28 November 2023

### **Planning Application: WH/23/02326/FUL**

#### Outstanding information for Validation of the above Planning Application

Planning application Drawing No. 05 (revision 00)

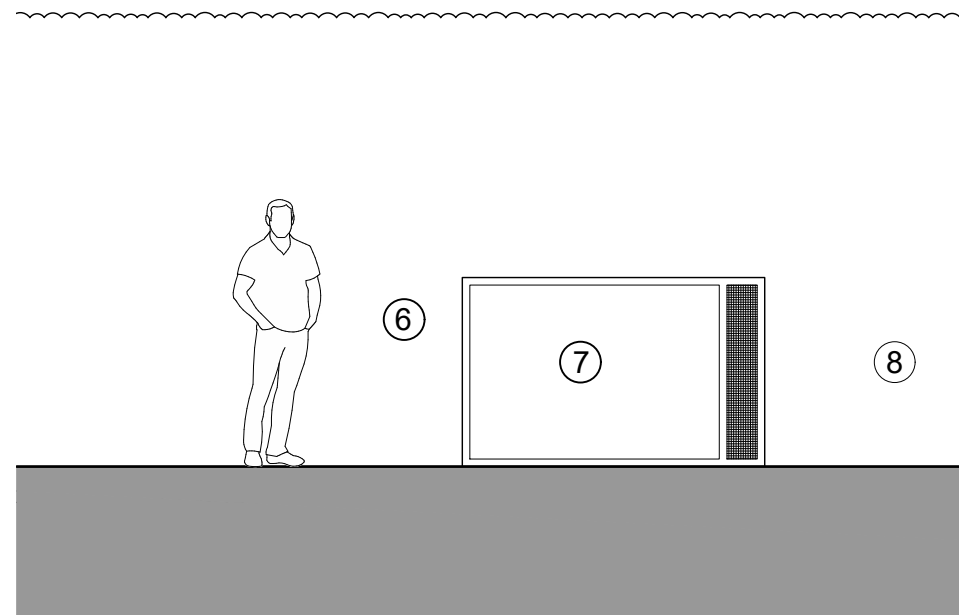
*Please provide Proposed Acoustic Enclosure Plan and Elevations (metrically scaled 1:10 or 1:20). Please also provide product specifications of the (assumed ASHP) heat pump particularly covering noise levels. These details should negate the requirement of a Noise Assessment.*

*Please provide a Proposed Entrance Elevation (metrically scaled 1:20).*

I have added a new drawing to the original application set (Drawing 05 rev.00) which gives the product specifications for the ASHP as well as the acoustic enclosure. This drawing also provides an elevation and image of the acoustic enclosure as requested. The location for the ASHP and enclosure is shown on Drawing 02 (revision 01).

The new drawing mentioned above (Drawing 05 rev.00) shows the elevation of the entrance gate. This is drawn at 1:50 as agreed by Mr Nemeth (Validation Officer) in his email to me of 19 October 2023.

Planning application Drawing No. 01 (revision 01)

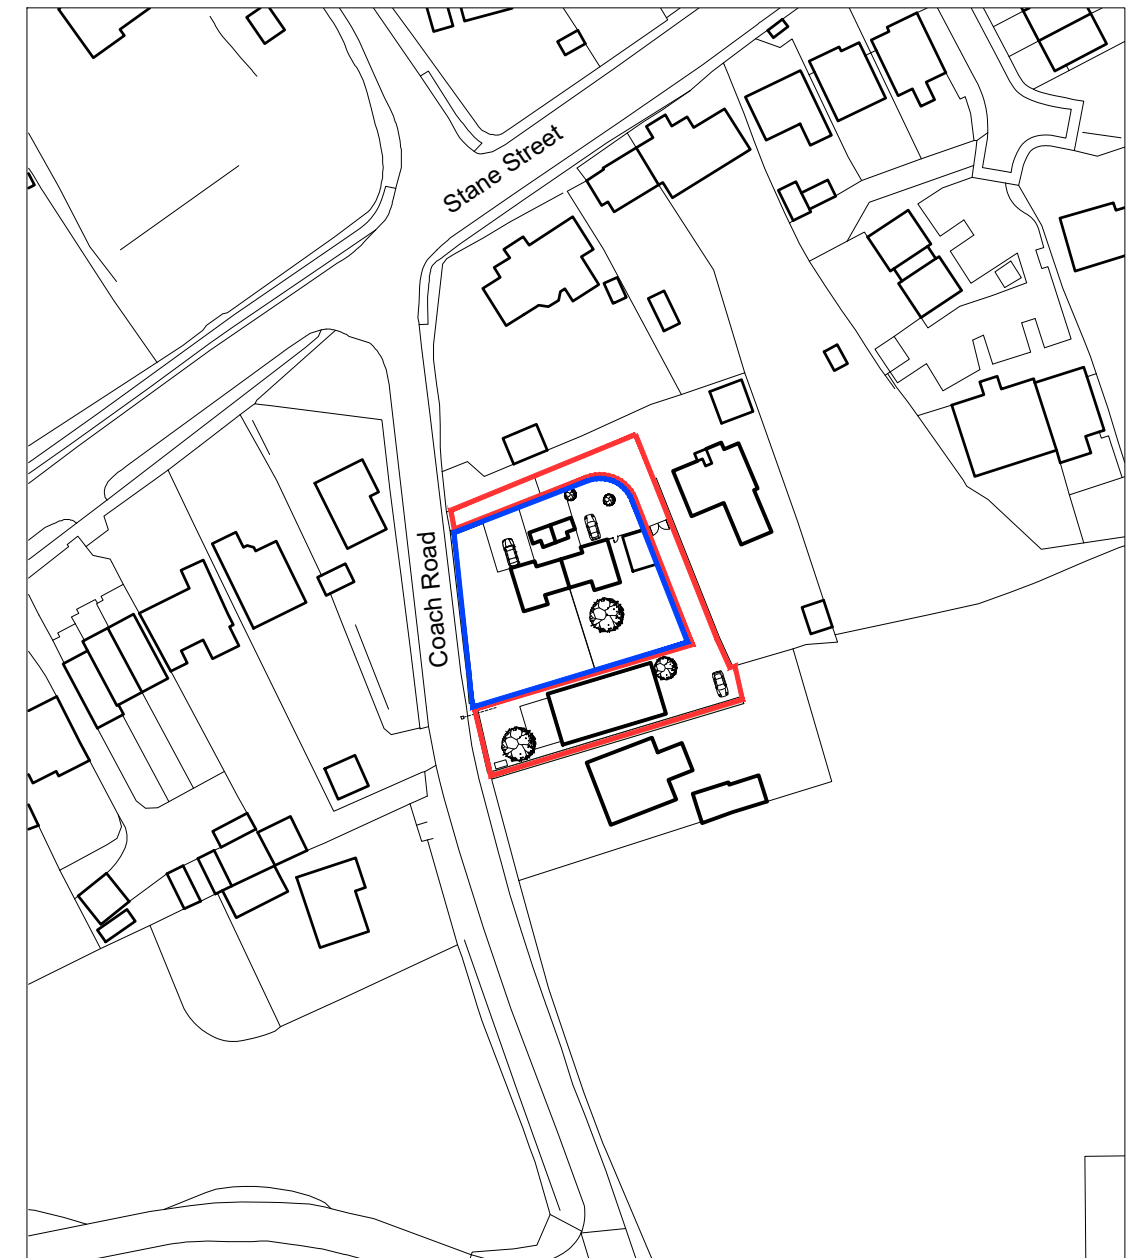
*Please provide an amended site location plan only edging in red application site and any other land in ownership of the applicant/owner in blue. The application red lined area should also extend to show access to/from a public highway and include an OS Licence number.*

The Site Plan, Drawing No. 01 (revision 01) has been amended and the OS Licence number is quoted in the notes to this drawing.
